OBSERVATION/SUBMISSION TO PLANNING APPLICATION

Case Reference: 324113

Re: Observation to the proposed development of open-cycle gas turbine (OCGT) and generator with ancillary equipment.

Location: Pollnagroagh and Rathmorrissy (Townlands), Athenry, Co. Galway

Purpose		PLANNING			
Title		SITE ACCESS SIGHTLINES			
Original Scale	Design/Drawn	Checked	Authorised		
SHOWN at A1	PS	ND	AJB		
Date	Date	Date	Date		
01.12.25	01.12.25	01.12.25	01.12.25		
Status	Drawing Number	Rev			
A2	PEK3-ATK-ZZ-01-DR-CE-901200	0

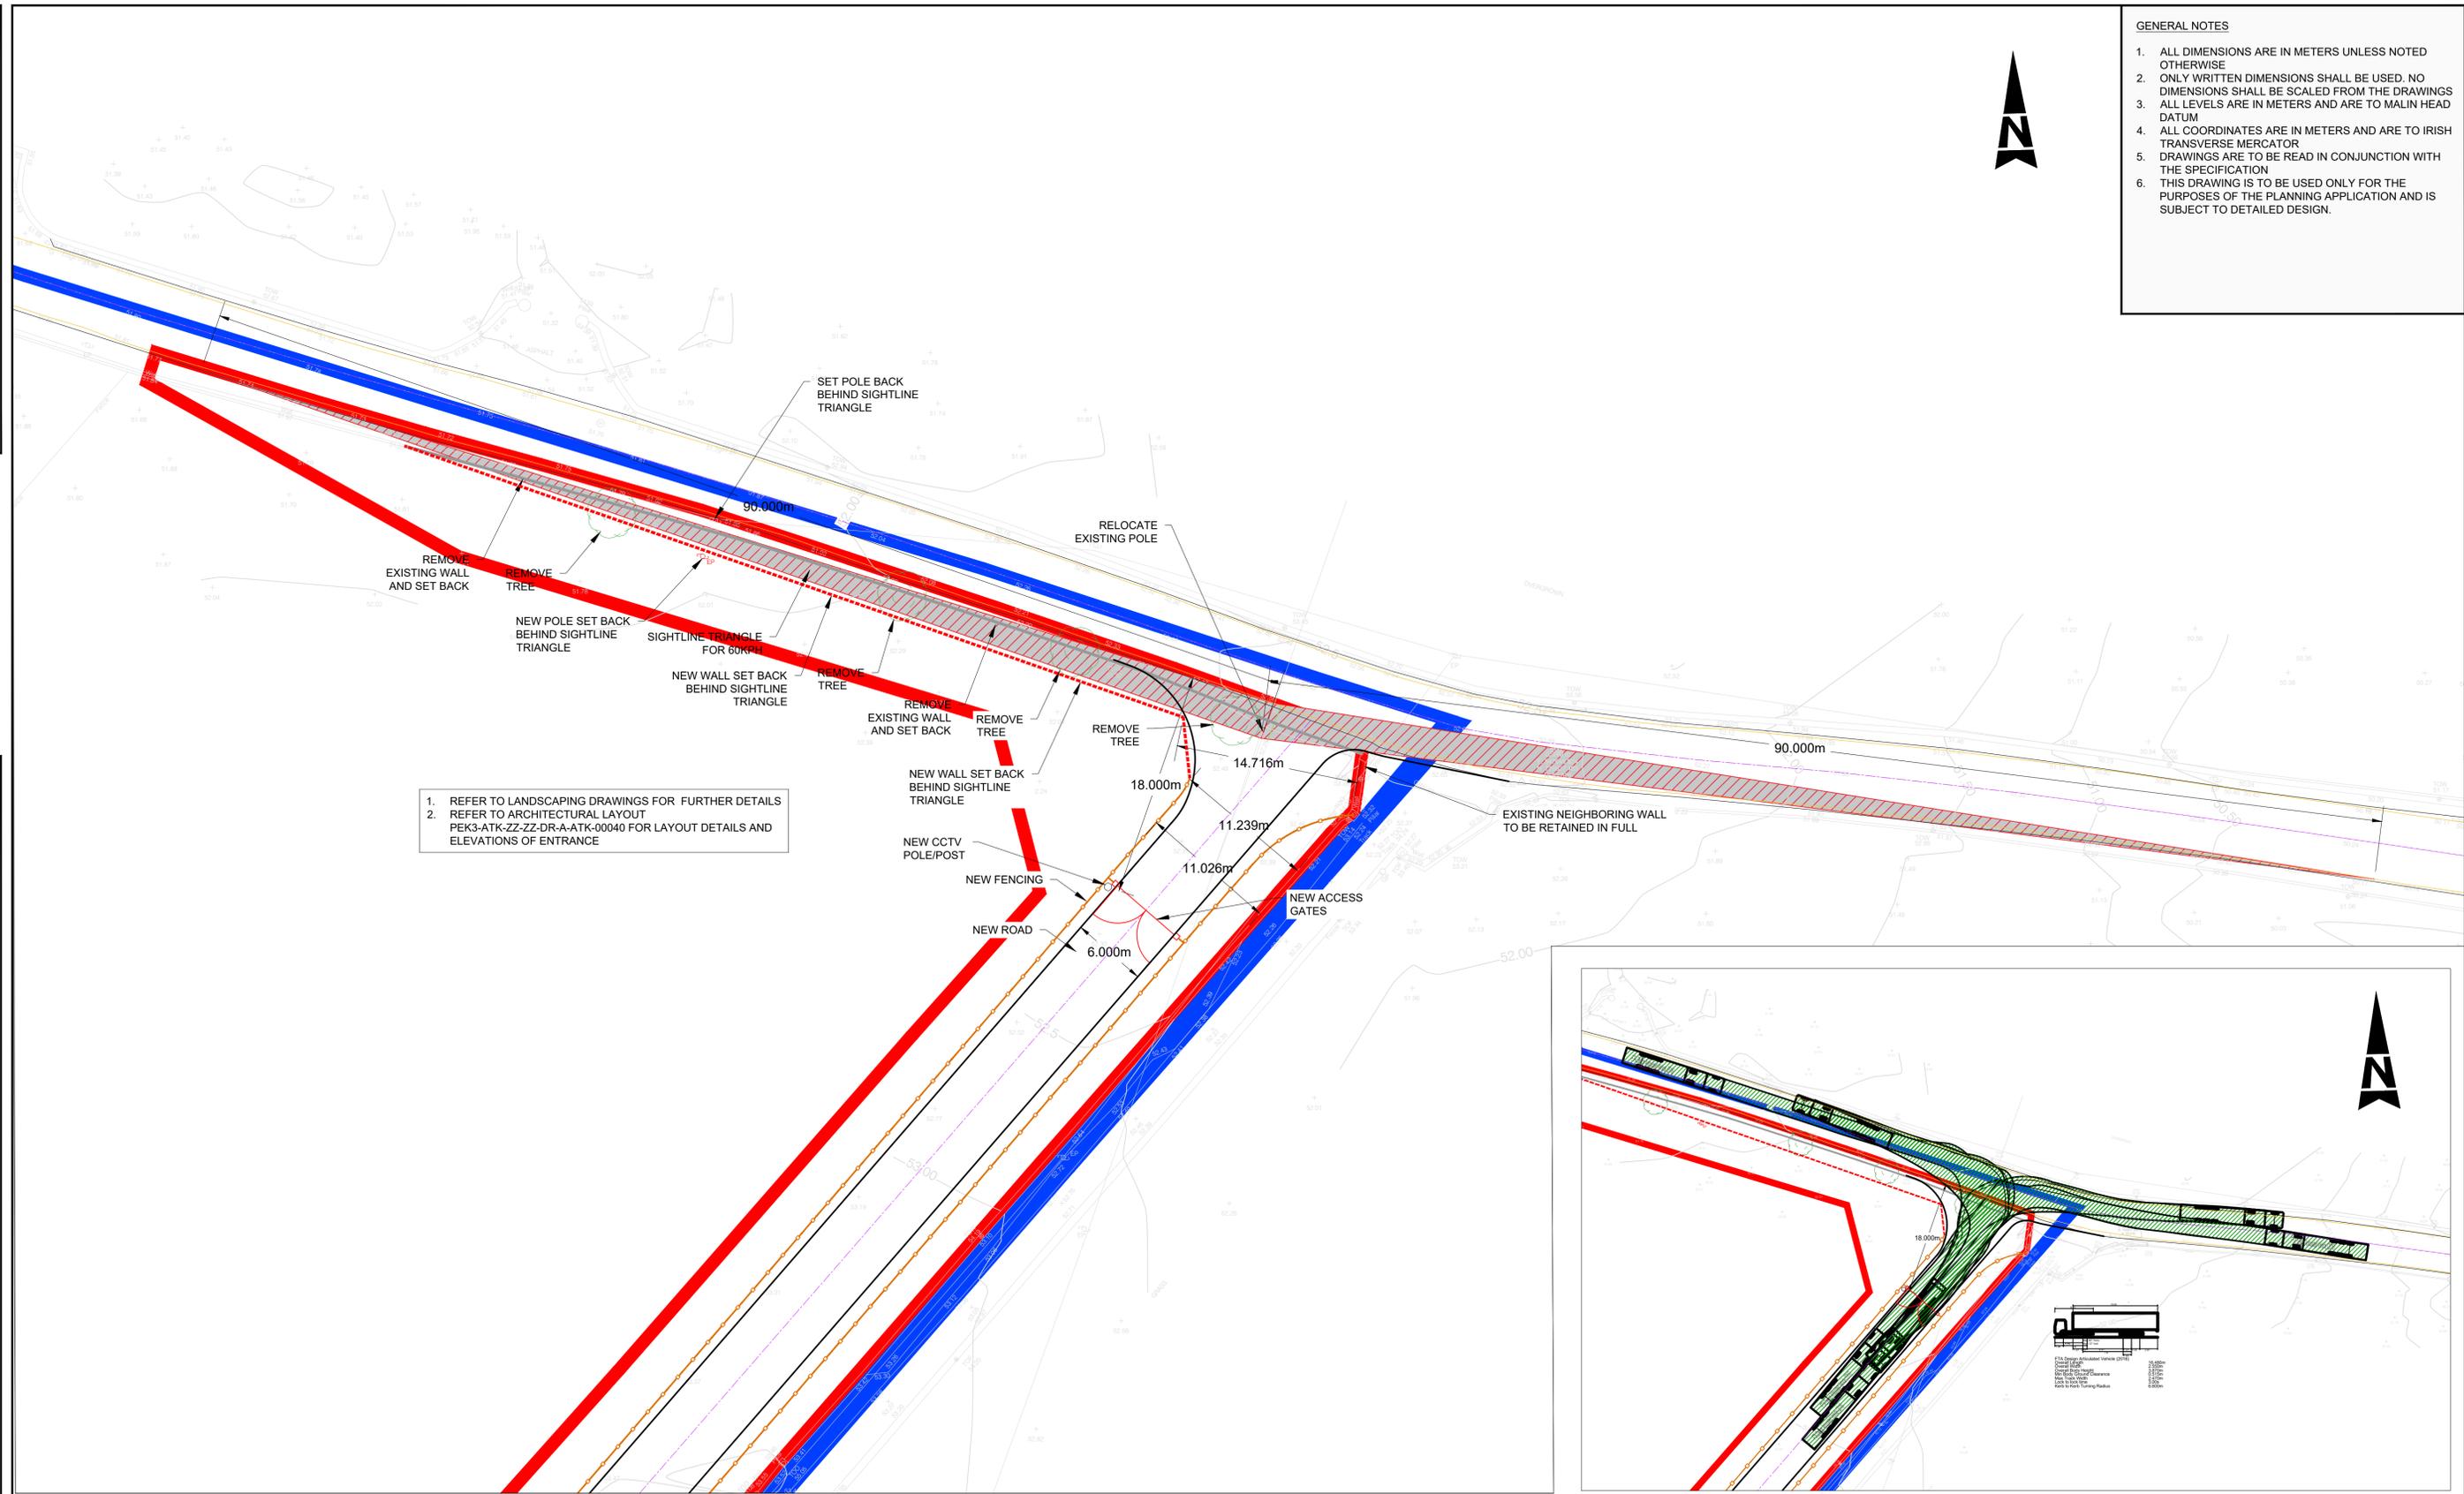
As someone who lives locally and uses this road, I am concerned about road safety in relation to the proposed entrance on the L3103. This stretch of road is already extremely narrow, with no hard shoulder, making it difficult for two heavy goods vehicles to pass safely and leaving no margin for error. Visibility is also poor due to blind dips and sharp bends, meaning drivers often cannot see oncoming traffic in time. The proposed development would increase traffic levels, including heavy goods vehicles, construction traffic, and fuel deliveries such as diesel tankers, all of which require space and clear sightlines that this road does not provide.

As someone who lives locally and extensively uses this road, I am concerned about the proposed location of the site entrance on the L3103. This section of road is already extremely dangerous, as it is narrow, has no hard shoulder, and does not provide sufficient space for two heavy goods vehicles to pass safely. Visibility is also poor due to blind dips and sharp bends, meaning drivers often cannot see oncoming traffic in time, and introducing a site entrance at this location would significantly increase the risk to all road users.

There are serious concerns about the proposed site entrance on the L3103, which is an exceptionally dangerous stretch of road where introducing an access point would create an unacceptable level of risk. The road is extremely narrow and cannot safely accommodate two heavy goods vehicles passing at the same time, there is no hard shoulder to allow for safe manoeuvring or recovery, and visibility is severely limited due to blind dips and sharp corners. These are significant existing hazards that already pose a real danger to road users, and the addition of a site entrance would further increase that risk.

The placement of a site entrance at this hazardous location on the L3103 raises serious safety concerns. The road is already constrained by its narrow width, the absence of a hard shoulder, and extremely poor visibility due to blind dips and sharp corners, yet the Environmental Impact Assessment does not appear to fully address the safety implications of introducing an access point at this location. There are also concerns that the cumulative impact of additional traffic has not been properly assessed, including construction traffic, ongoing operational traffic, and fuel deliveries, and the interaction between heavy goods vehicles and existing road users—such as local traffic, school-related movements, and agricultural machinery—has not been
